About the application

Application number: 2024/90462	
What is the application for?:	Change of use of land to domestic garden and erection of garden room with associ
Address of the site or building:	53, Heaton Road, Paddock, Huddersfield, HD1 4HZ
Postcode:	HD1 4HZ

PROPOSED PLAN 1:100

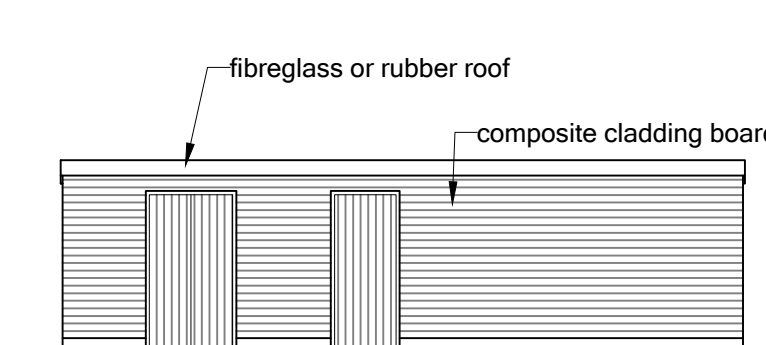
Type of comment: An objection	
Do you wish your comments to be published on the website anonymously?	Yes
1. Scale of garden house. It covers most of the width of the plot. Effectively the natural garden will be lost. The application says it is rough grassland but is already been covered with building waste. 2. Change of use. I understand that the land has been sold or will be sold by Kirklees to the applicant. Other sales in this area have been conditioned by the vendor to prohibit permanent buildings. We assume that is the case here, Details of the building are not clear. This needs to be clarified to prevent a precedent of constructing permanent buildings on urban green space. 3. The application area abuts the Gledholt Woods Local Nature Reserve. The value of this is understated by the author of this section of the application who did not visit the site. The aerial photo submitted shows flower beds in the front garden which is now covered in tarmac. There are ponds in neighbouring gardens with newts and frogs. Foxes and deer are seen frequently. Bats can be seen over the gardens in the evenings
